From: [Cascade Irrigation](#)
To: [Chace Pedersen](#)
Subject: RE: SP-23-00004 Singer - Notice of Application
Date: Thursday, July 6, 2023 10:10:53 AM
Attachments: [Comment Letter.pdf](#)

To: Chace Pedersen, Planner I
From: Kim Shilley, Public Health Technician
Date: 7/19/2023
RE: SP-23-00004 Singer

TO: All Staff
FROM: Public Works Plan Review Team
DATE: July 24th, 2023
SUBJECT: Public Works Comments: SP-23-00004 Singer

## SINGER SHORT PLAT PART OF SECTION 5, T. 17 N., R. 19 E., W.M. KITTITAS COUNTY, WA

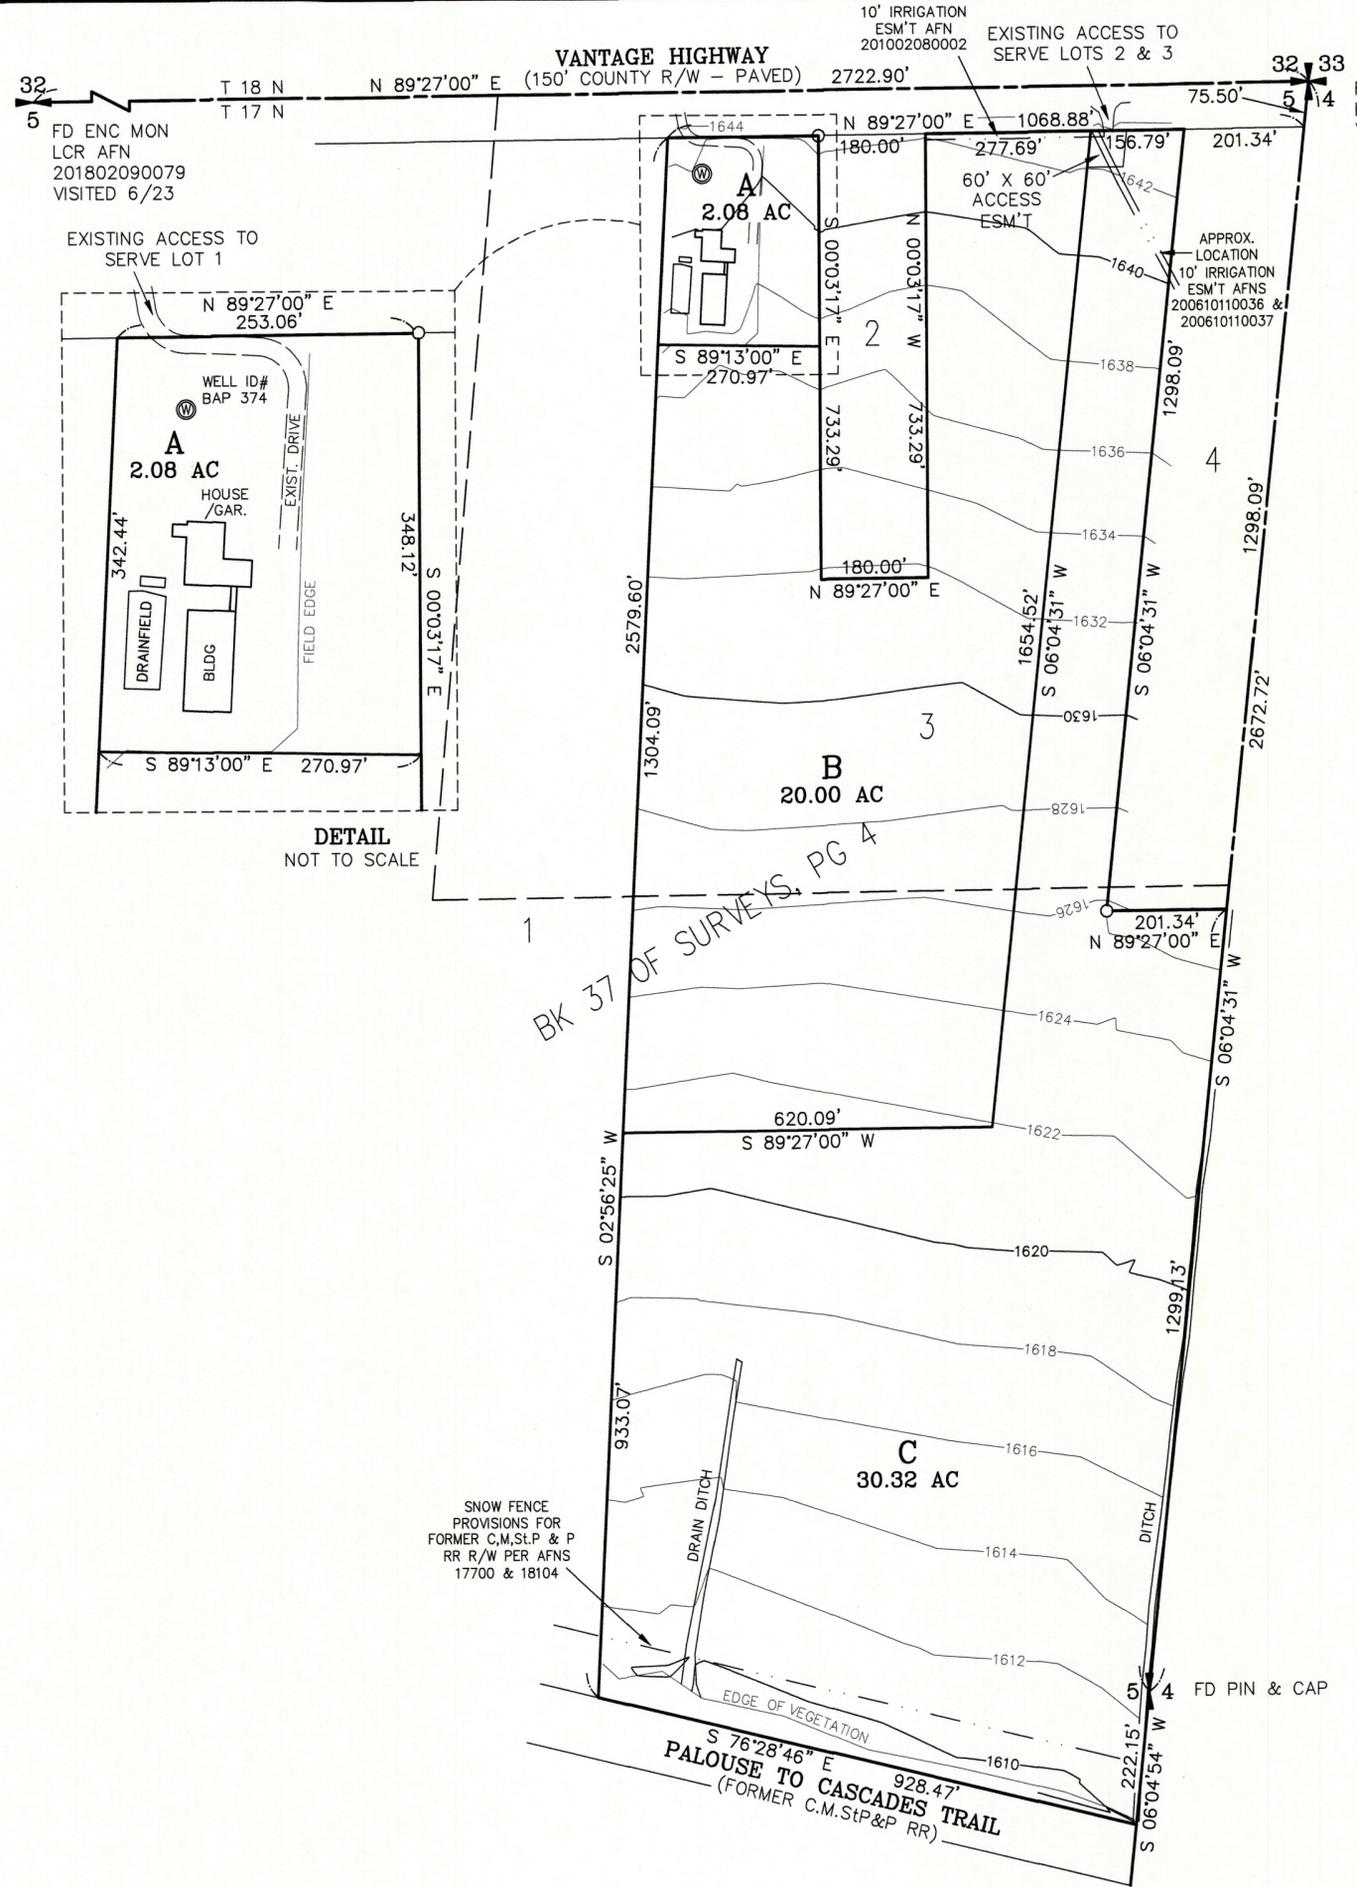
1. Access and turn around for lots 2 and 3 meet current applicable road standards and fire code – Appendix at time of development.
2. Addressing be clearly visible from both directions of travel.

Proposed short plat indicates shared wells will be used. If shared wells are to be utilized, the wells must be drilled a minimum of 50 feet from any proposed property line and a signed, notarized and recorded shared waters users' agreement for each shared well must be submitted to our office prior to final plat approval. The applicant must prove physical availability of water for all new uses of water proposed lots of this project, which can be provided by (See Condition A-1) a well log or 4 hour draw down test as proof of water availability for each new well proposed. All persons who are making applications for land use including but not limited to short plats must comply with KCC Chapter 13.35.020.
